Hawkesbury City Council

Hawkesbury City Council Submission of RMS Windsor Bridge Replacement EIS

Windsor Bridge Replacement – EIS comment Hawkesbury City Council 14 December 2012

Figure 5-1a | Key project elements - Southern Approach

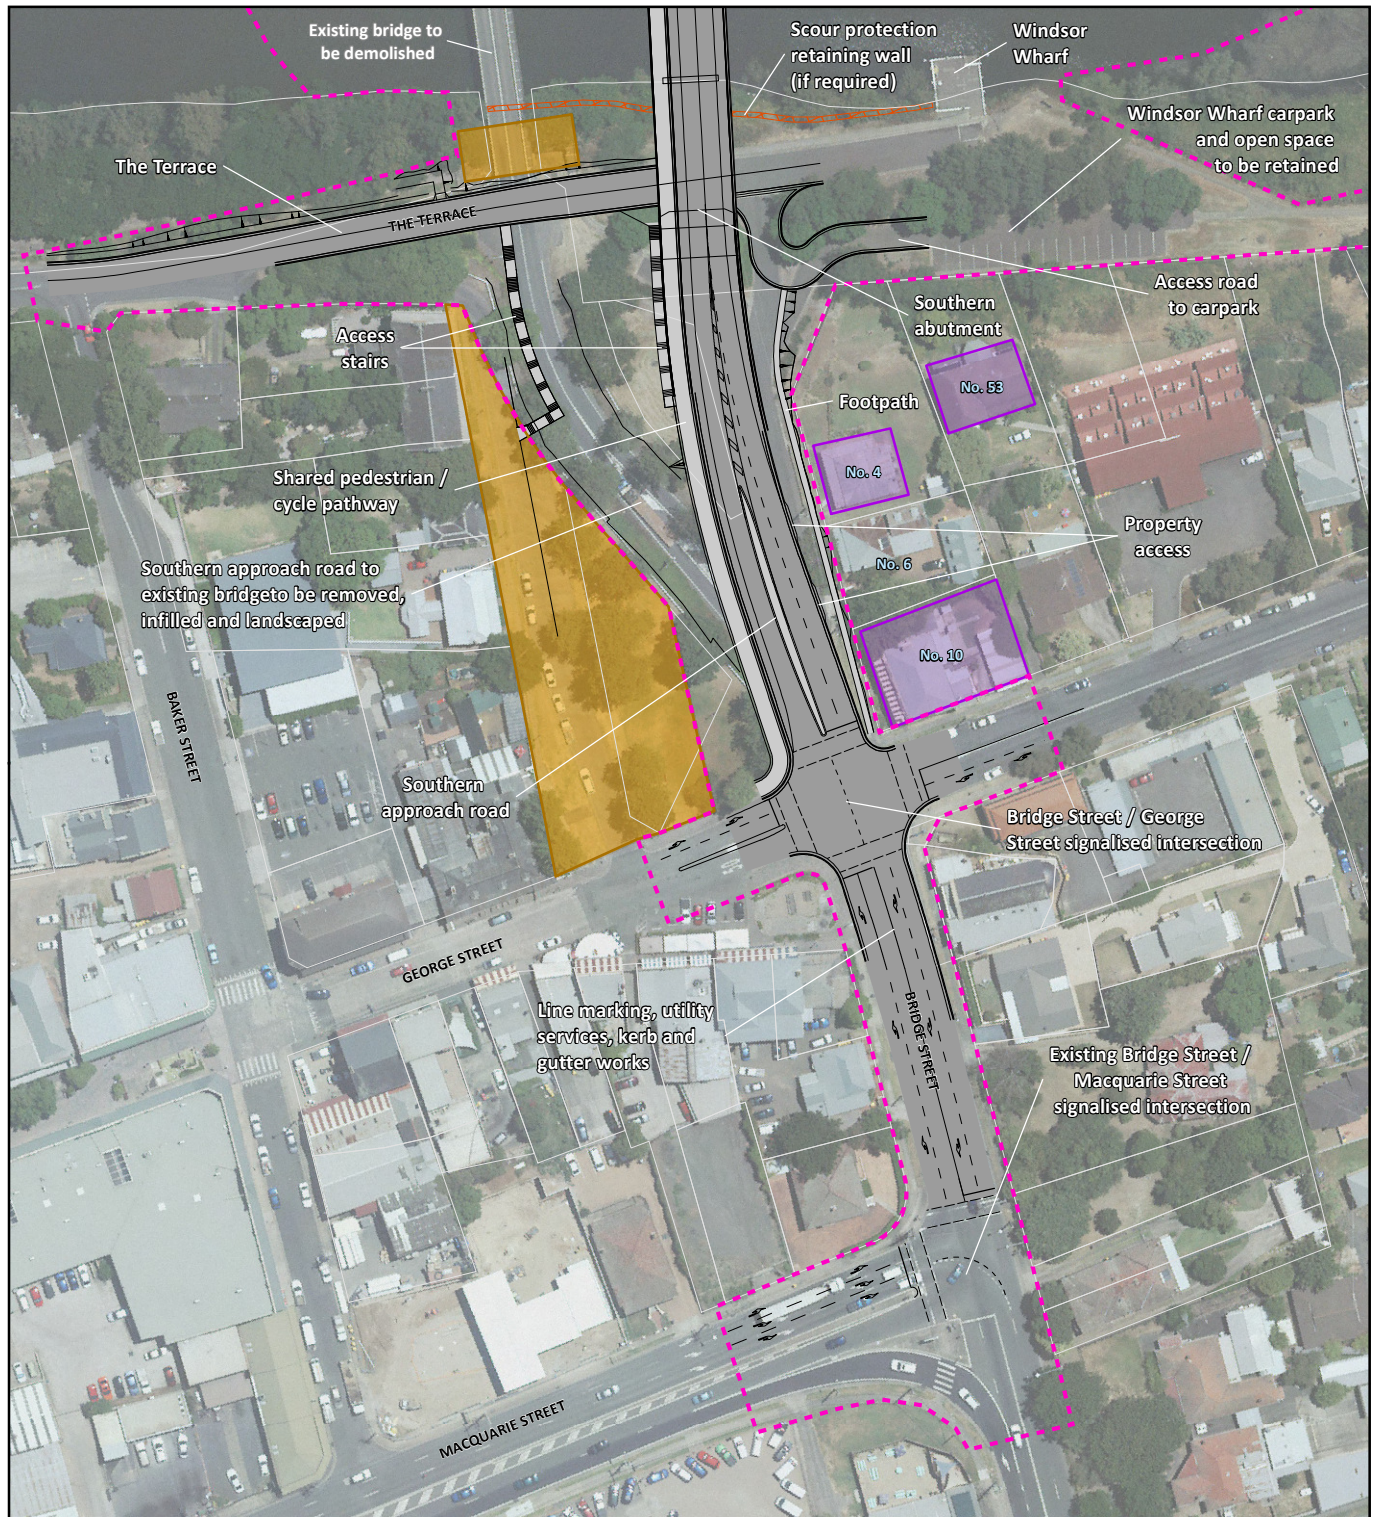
5. Area 8 on Figure 8.1 Volume 3 appears not to have a design concept or material proposed. The materials for the pavement (Plate 8.3) identified in Section 2 in George Street could be used within the George Street entry into Windsor.

15. The texture of the road pavement needs to be differentiated to indicate an arrival point into Windsor and the pedestrian environment. This should continue east (Macquarie Street) and south (to Thompson Square Road) to connect with the extent of the project scope i.e. the red construction work zone lines shown on Figure 6.4 in Volume 3.

FIGURE 5-3 | Western Elevation of replacement bridge

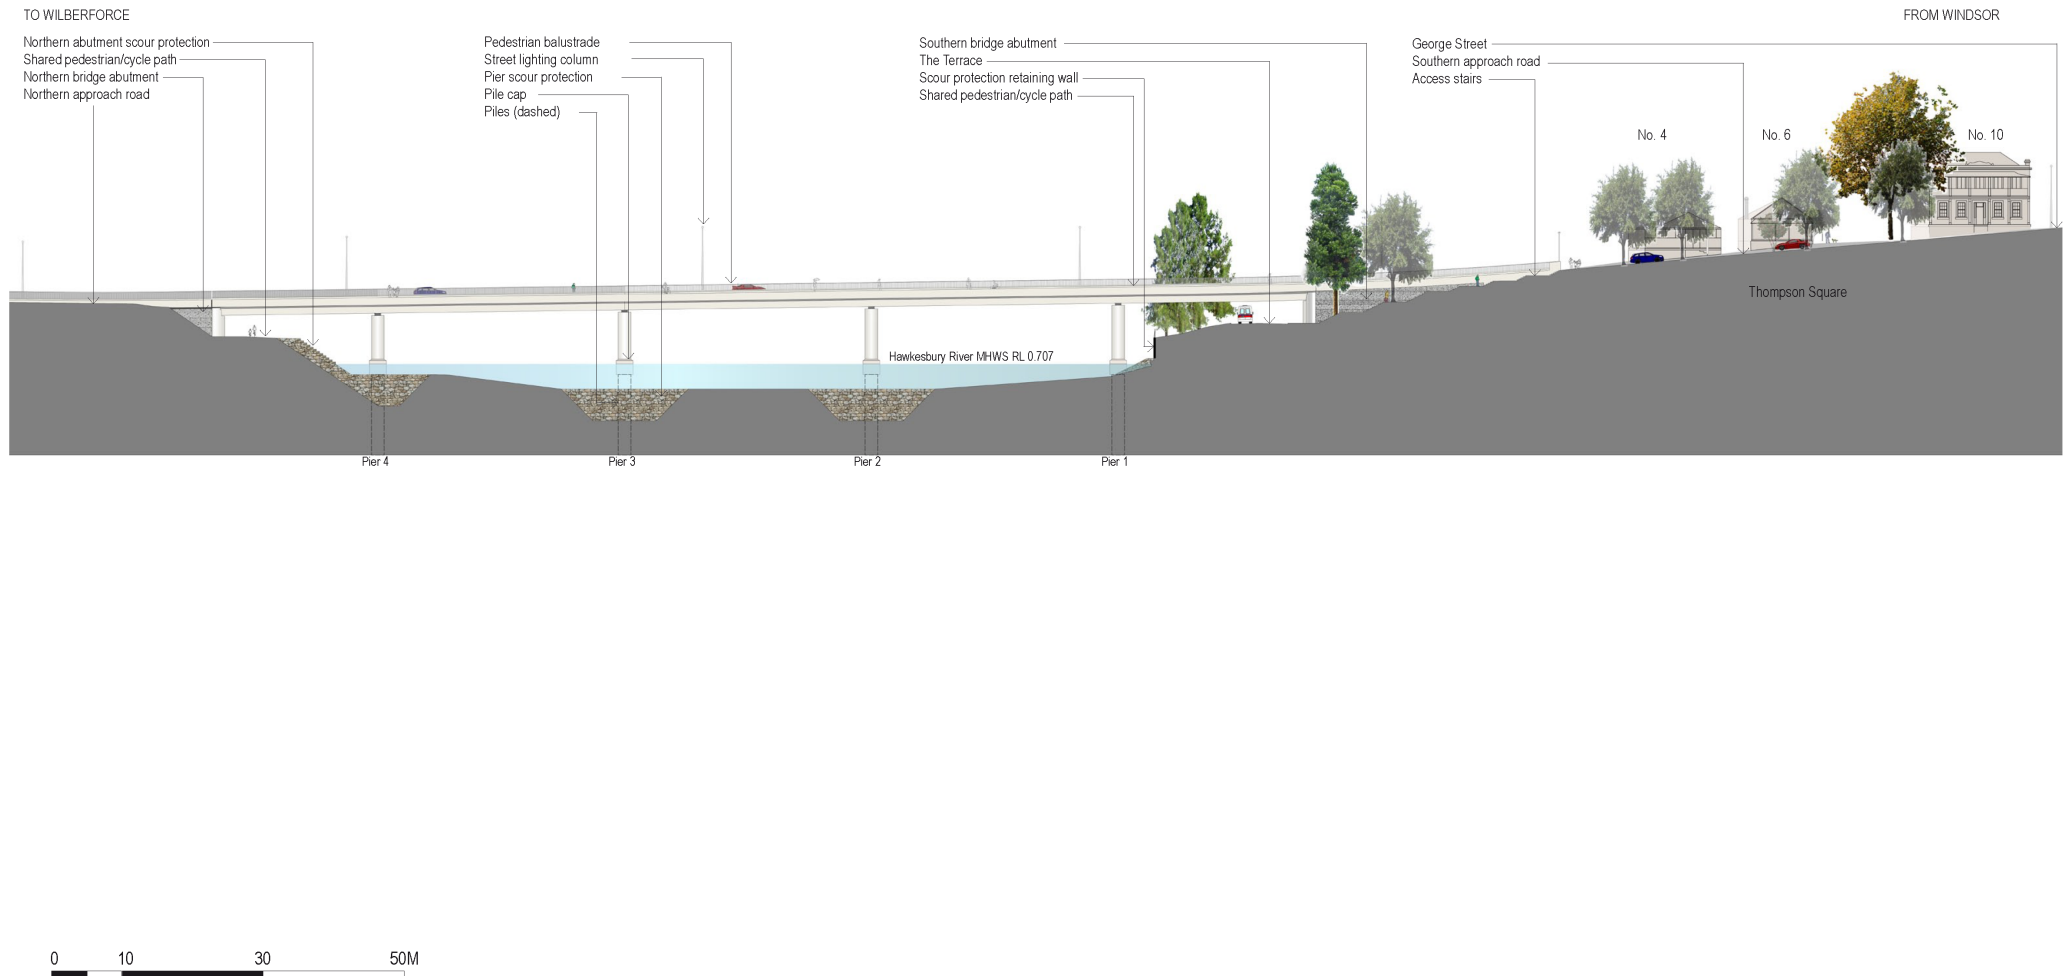
12. Whilst the contemporary bridge style is accepted where it crosses the river, the generic treatment of the bridge elements (eg. Abutment, road, railings etc.) on the southern bank are not considered appropriate. From the point at which the bridge 'lands' on Southern bank the materials palette for the bridge and the square should be considered.

- b. The Southern abutment could be a dry laid stone wall (similar to the one at the Doctor's House) to complement Thompson Square.
17. Terrace Road access to the wharf area is identified at a 3.6m clearance, however, this height will not maintain the existing 4.3m height for coach access. A modified height to achieve coach access is required and may impact on the design elements and the constructed levels for The Terrace pavement.
